### DRB CASE ACTION LOG (PREL & FINAL)

DRB Application No.: 04DRB-01070 (P&F)

Project # 1003487

Project Name: BELMONT ADD. - HARWOOD ADD.

SHEET 1 OF 2

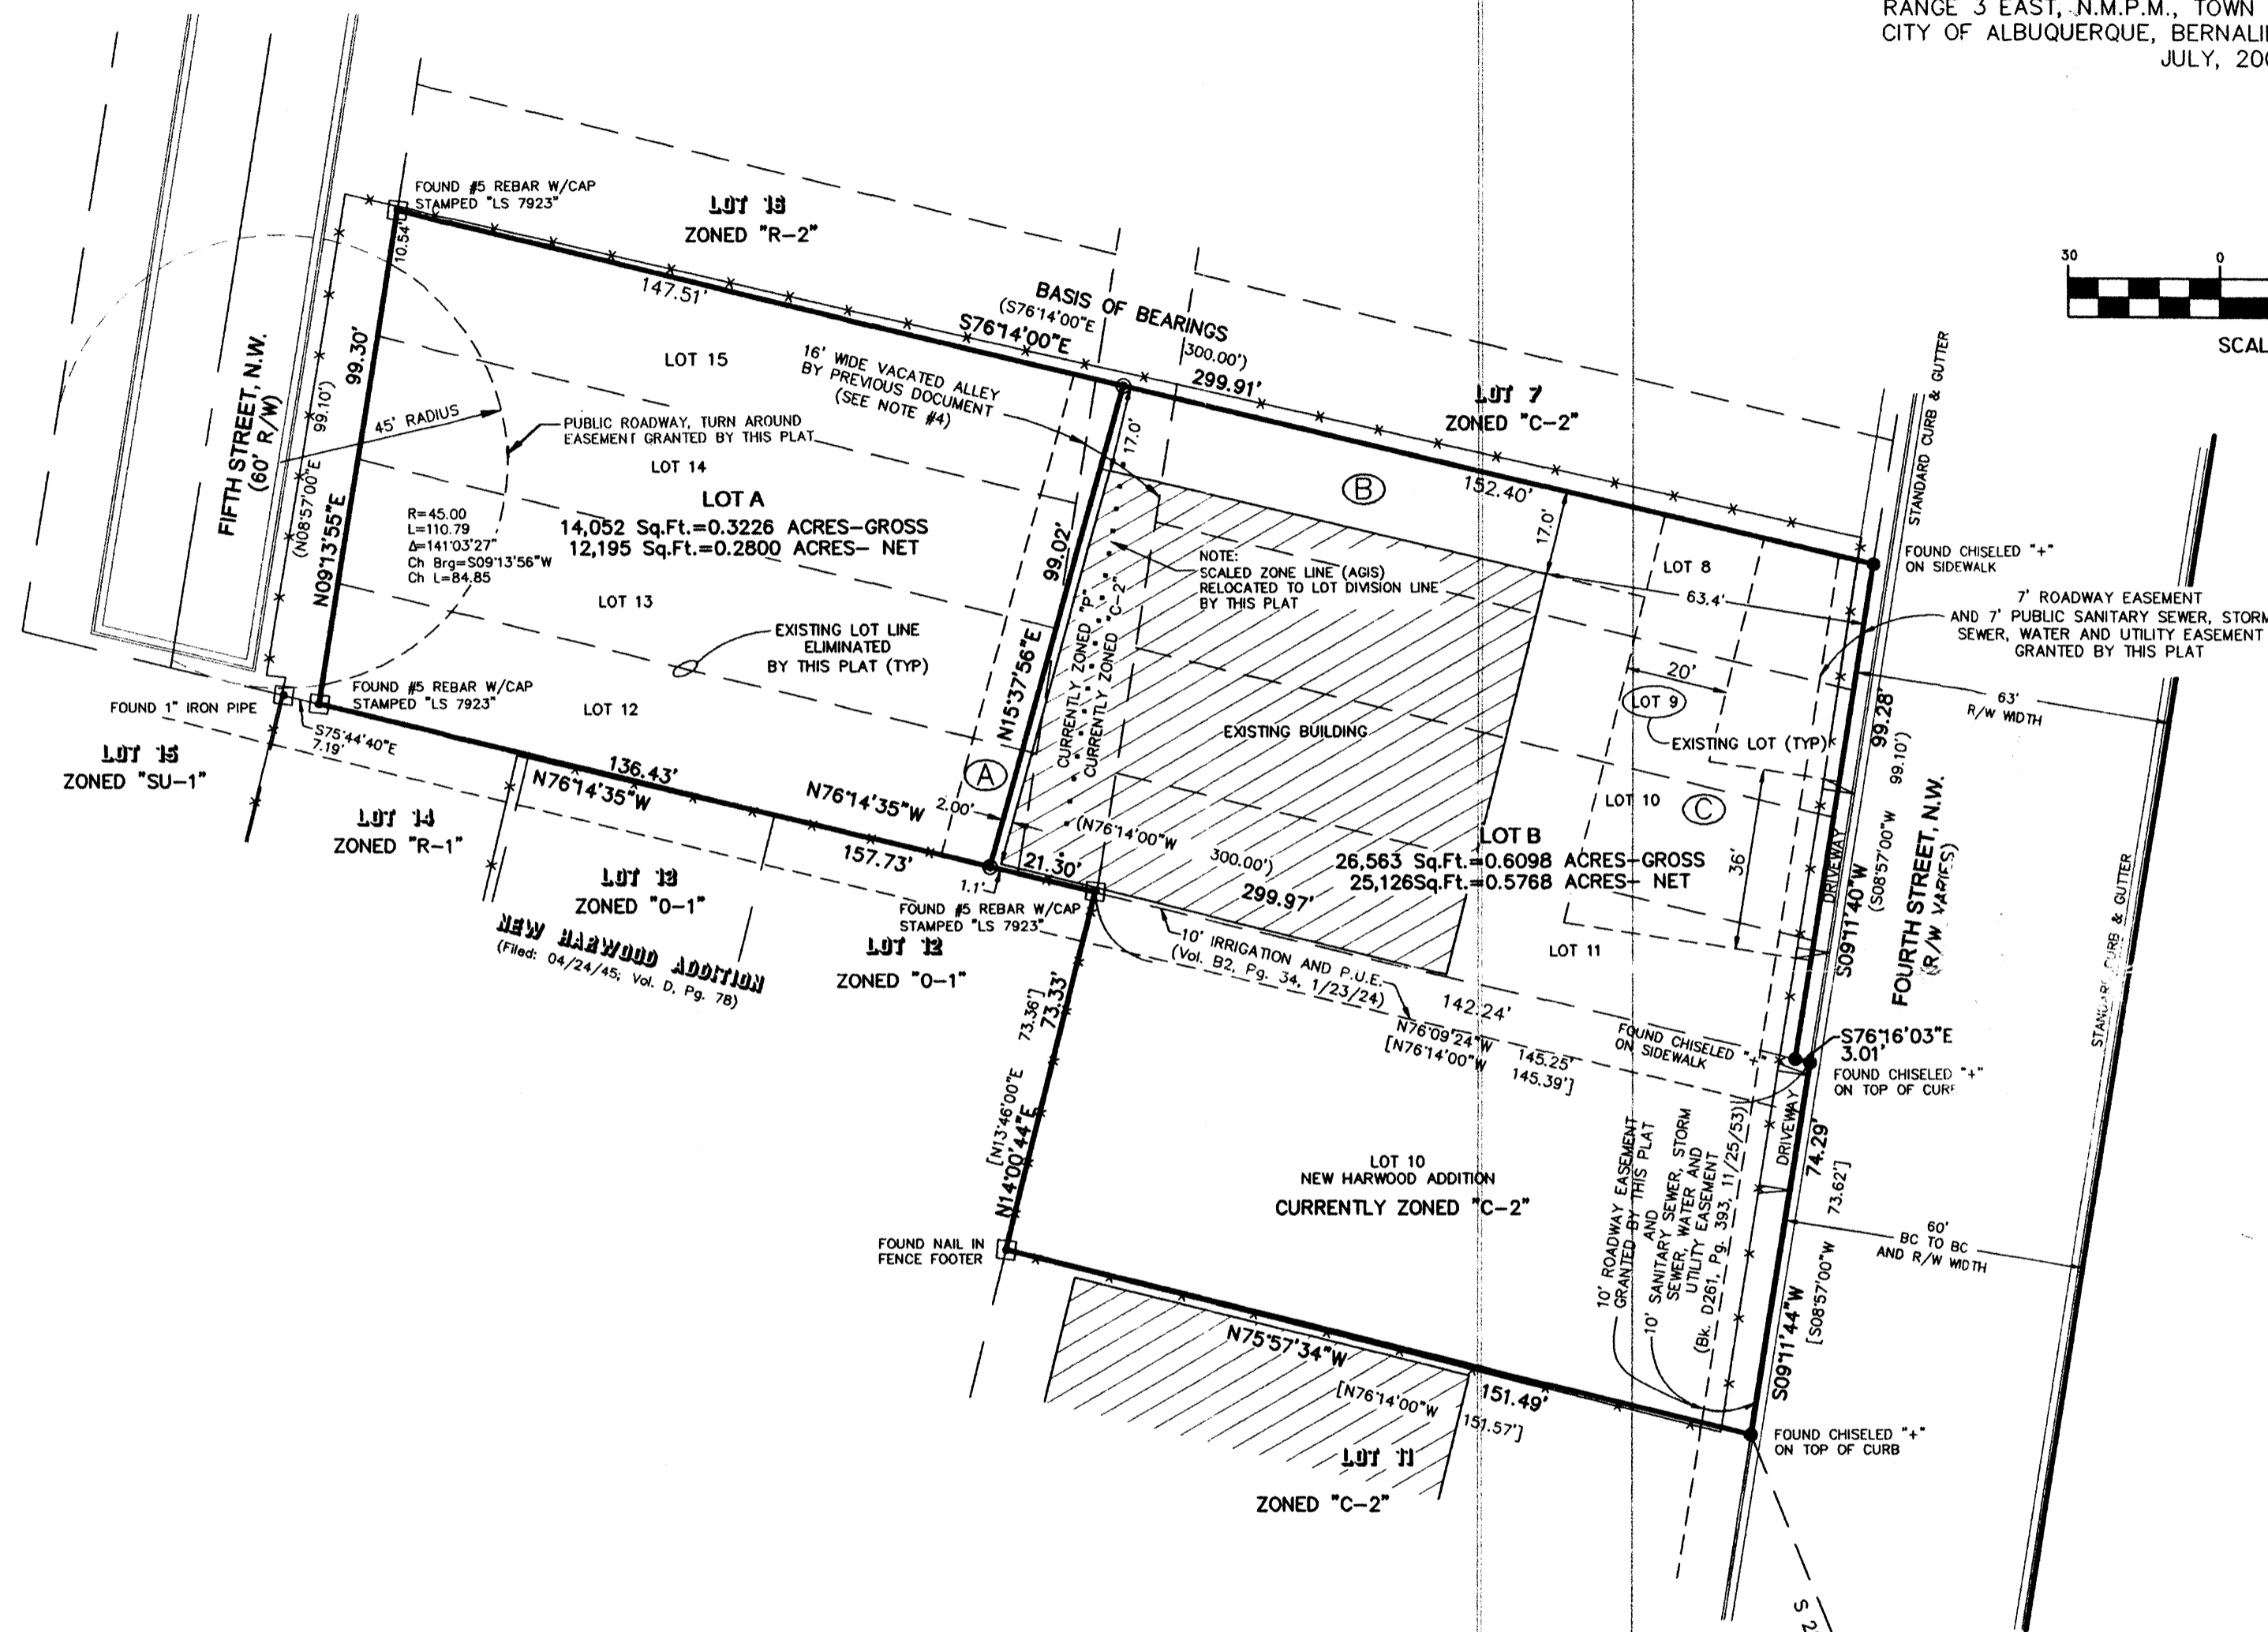
Agent was called & asked to update the signature block on the final plat mylar prior to DRB signing it.

SKETCH PLAT LOTS A AND B

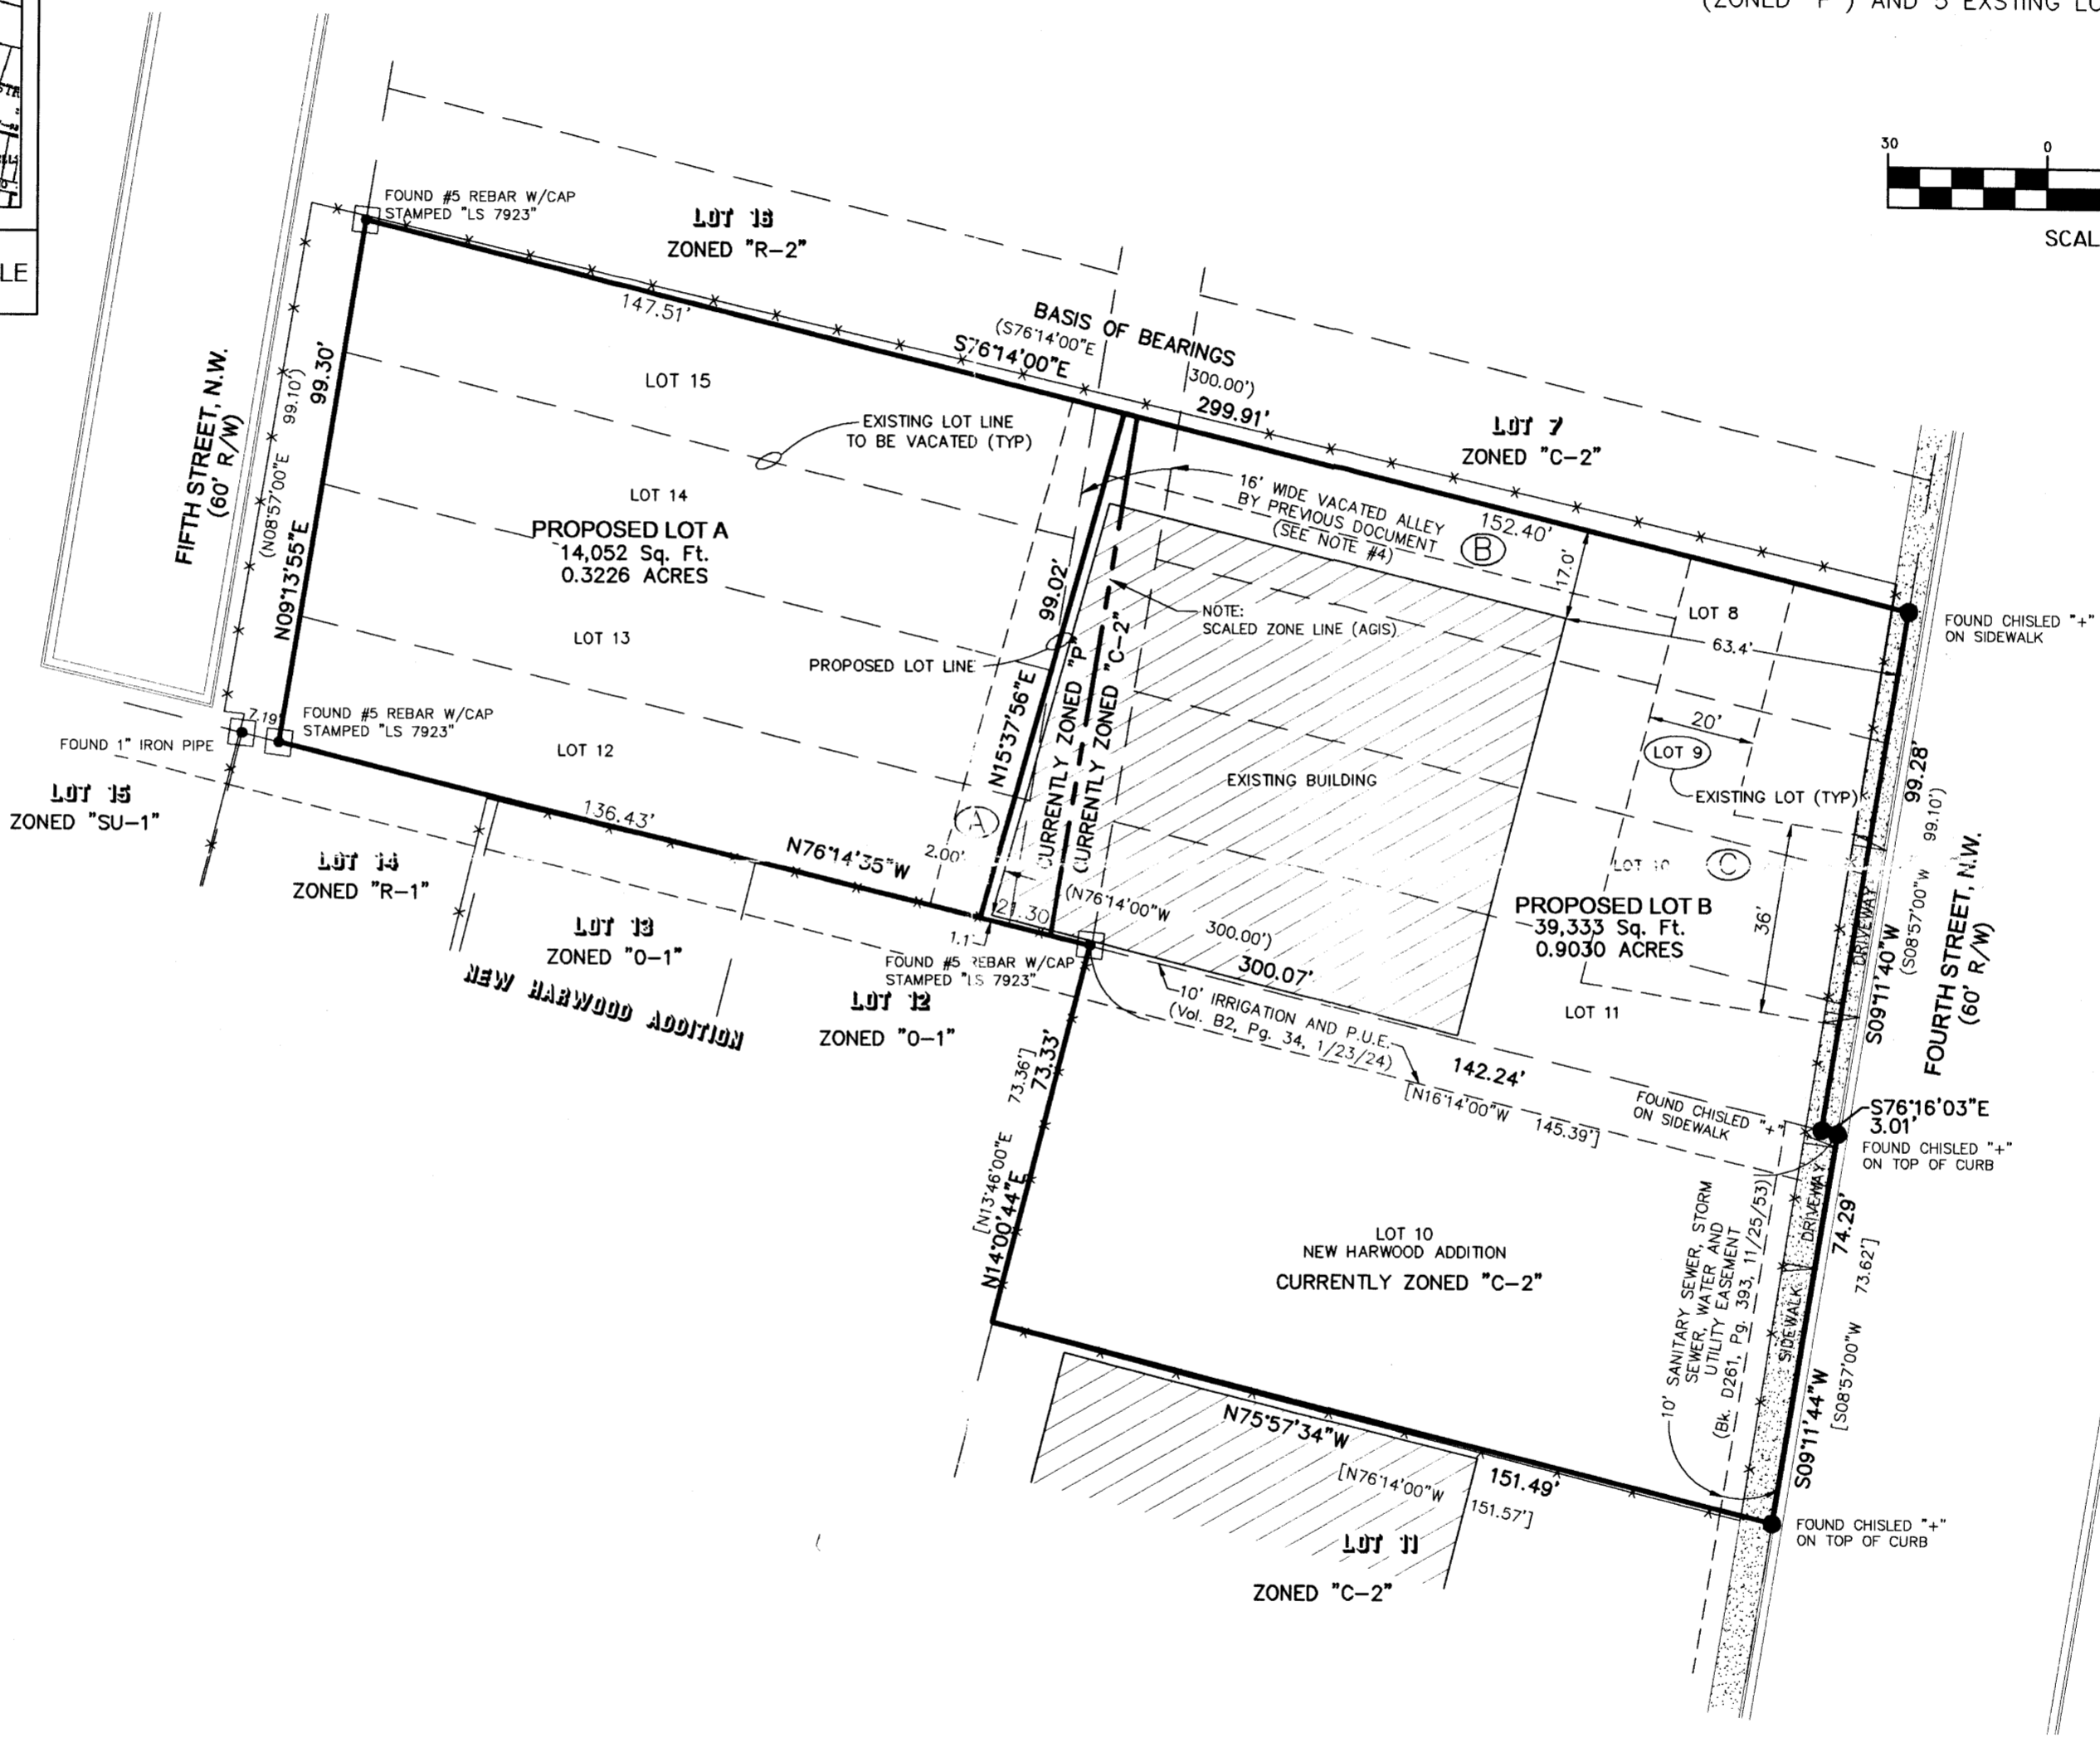
The two separate zoning on the parcels is a different matter. First of all, proof of the alley vacation and what happened to the alley when it was vacated is needed. Was it divided in half equally and added to the property on either side or was it purchased solely by the property owner or just one side? Or some other arrangement is possible. It is the agent's responsibility to determine what happened & bring that proof to DRB.

Secondly, if the proposed replat includes any portion, no matter how small, of the P property as part of the C2 property, an application for re-zoning is necessary.

For C2 zoned property, O1 building setbacks apply. Since the lot line is moving, the applicable setback width should be met by this change.

*9/1/04 - Ellen Concini  
said for this small  
"slice" of property zoned  
& not rezoned to make lot line*
